Local Policing Support Team

Your Ref: BR/114/20/PL

RE: 13-17 Abbeyfield Richmond Avenue Bognor Regis PO21 2YE

Thank you for your correspondence of the 19th May 2020, advising me of a planning application for Conversion of existing vacant residential care home into 10no. flats at the above location, for which you seek advice from a crime prevention viewpoint.

SITE PLAN 1:500

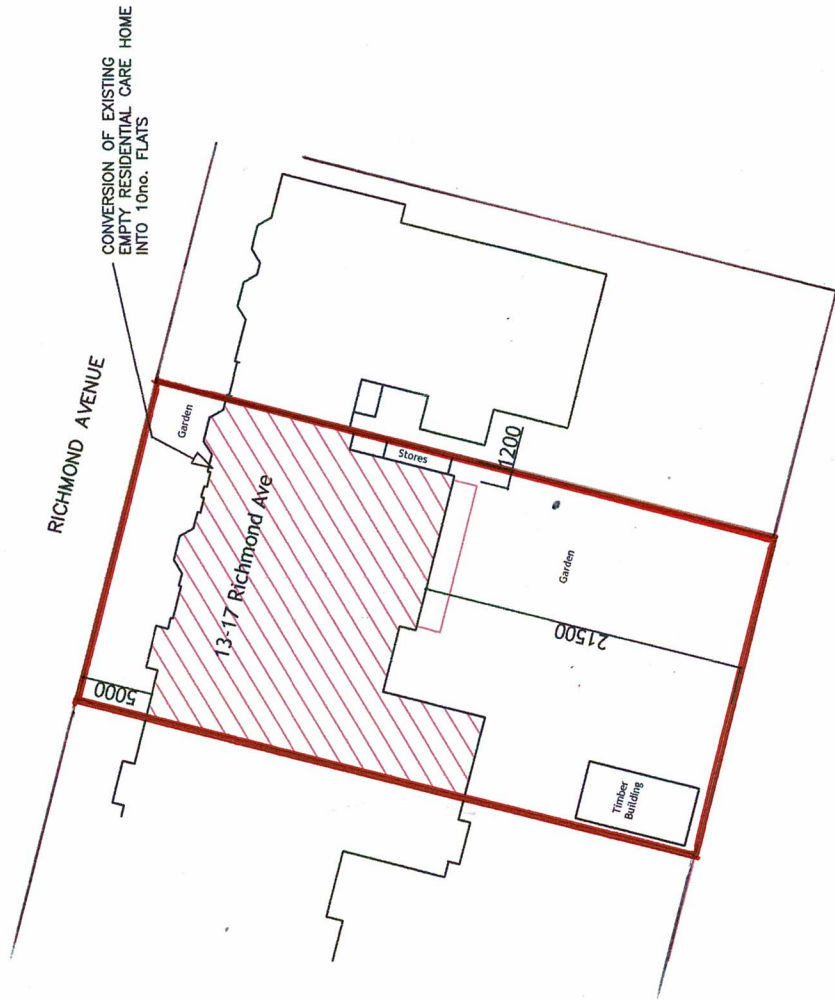
With regards to the rear car park - where communal parking occurs it is important that they must be within view of an active room within the property. An active room is where there is direct and visual connection between the room and the street or the car parking area. Such visual connections can be expected from rooms such as kitchens and living rooms, but not from bedrooms and bathrooms.

Boundary fencing to the site needs to be robust and I therefore refer the applicant to SBD Homes 2019 Version 2 Chapter 10 Dwelling Boundaries 10:6 through to 10:6 :6

With regards to the external bin and cycle stores I refer the applicant to SBD Homes 2019 chapters 56 56:1 through to 56:4 and additionally Chapter 57 57:1. These chapters will give the applicant additional information pertaining to security to these areas.

DRAWING
PROPOSED PLANS
DRAWING No
313/03
SCALE 1:100
DATE APRIL 20
DRAWN LA
CHECKED

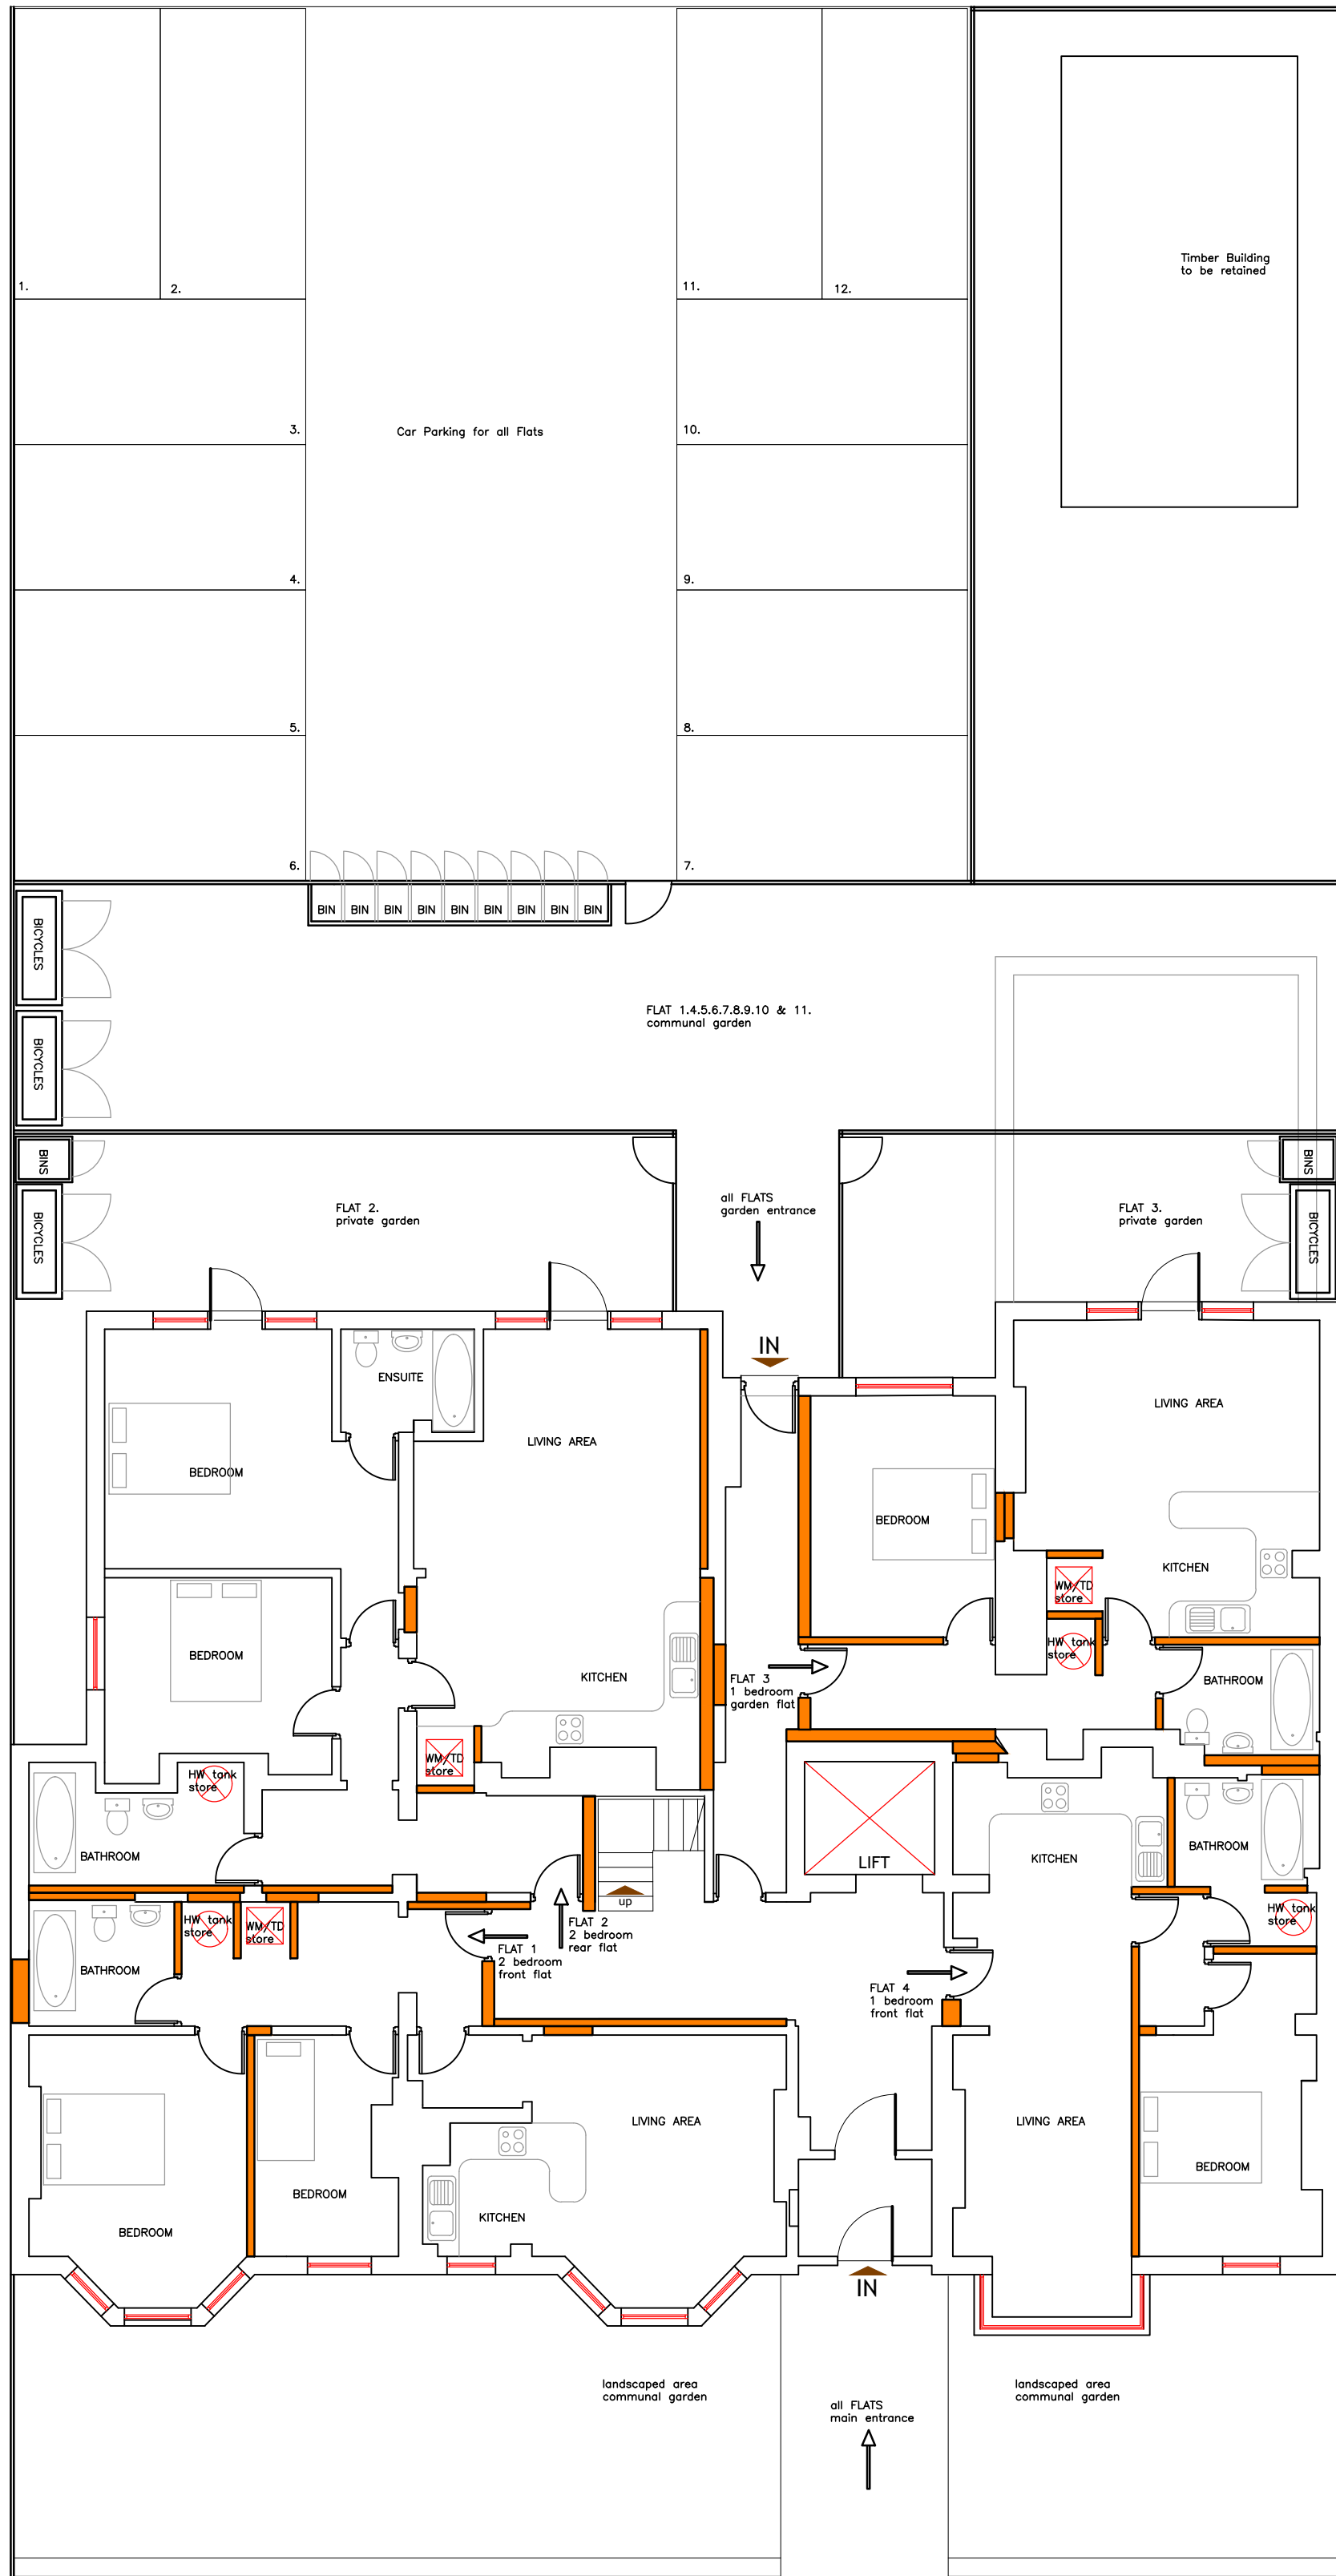
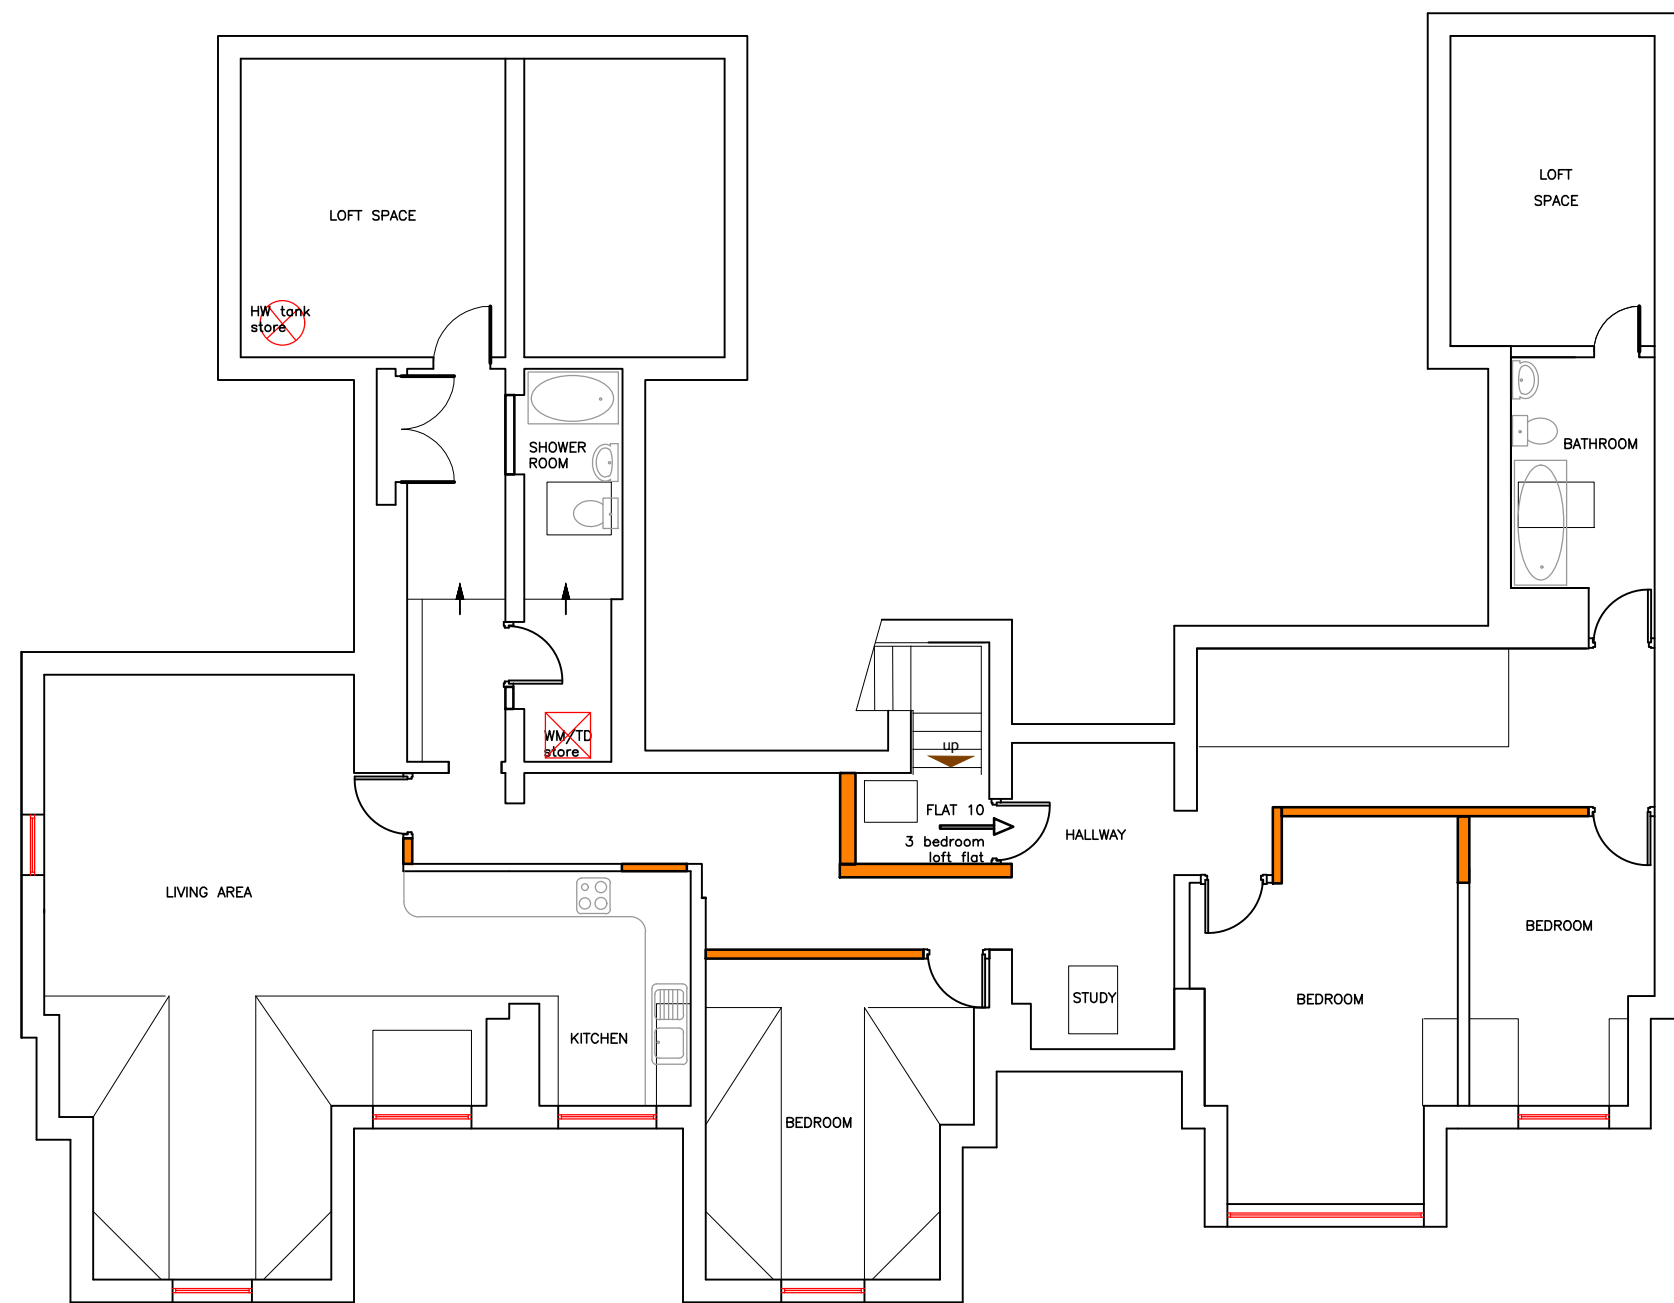
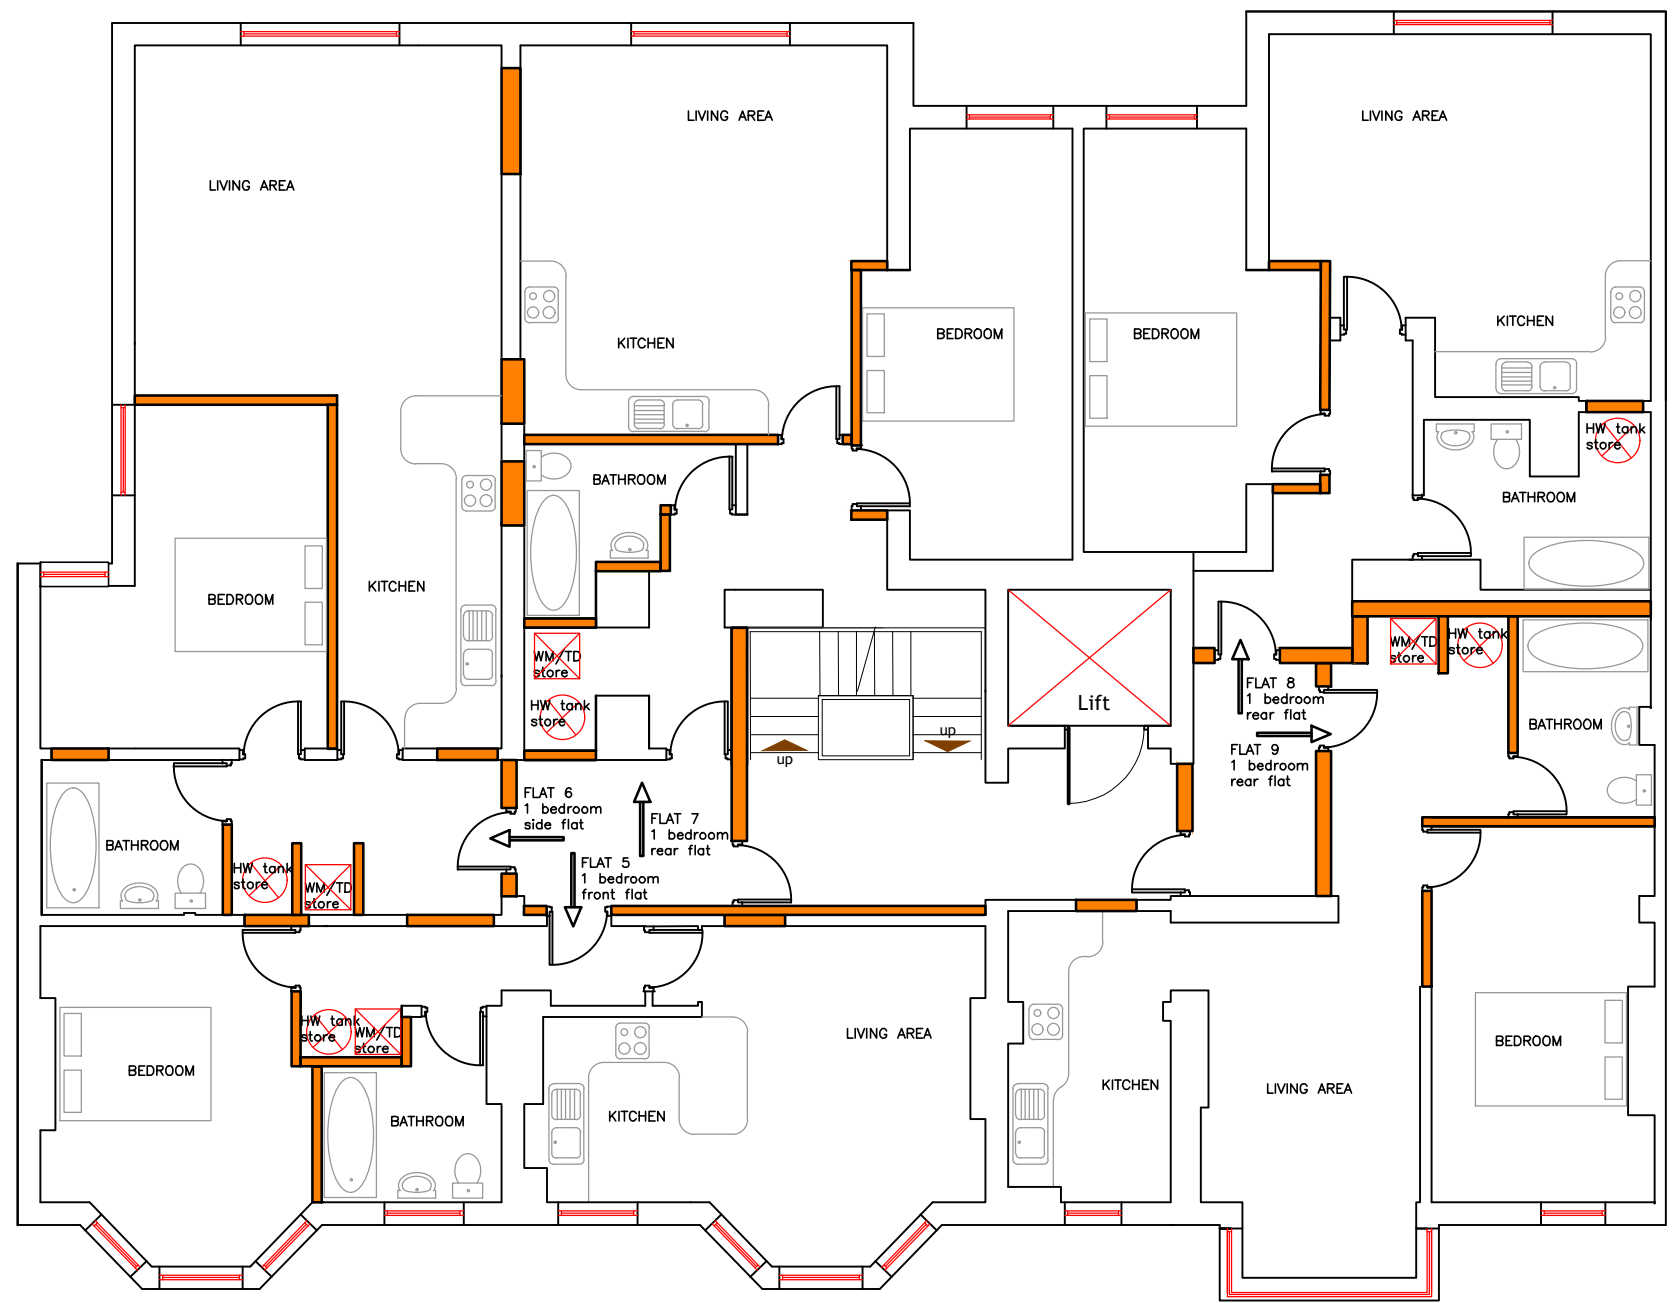
It is important that the boundary between public space and private areas is clearly indicated. This is especially important with regard to the private garden areas proposed for flats 2 and 3. It is desirable for dwelling frontages to be open to view, so walls fences and hedges will need to be kept low or alternatively feature a combination (max height 1m) of wall, railings or timber picket fence.

The lower ground windows which abut the private gardens to flats 2 and 3 should be fitted with restrictors to allow ventilation without compromising security.
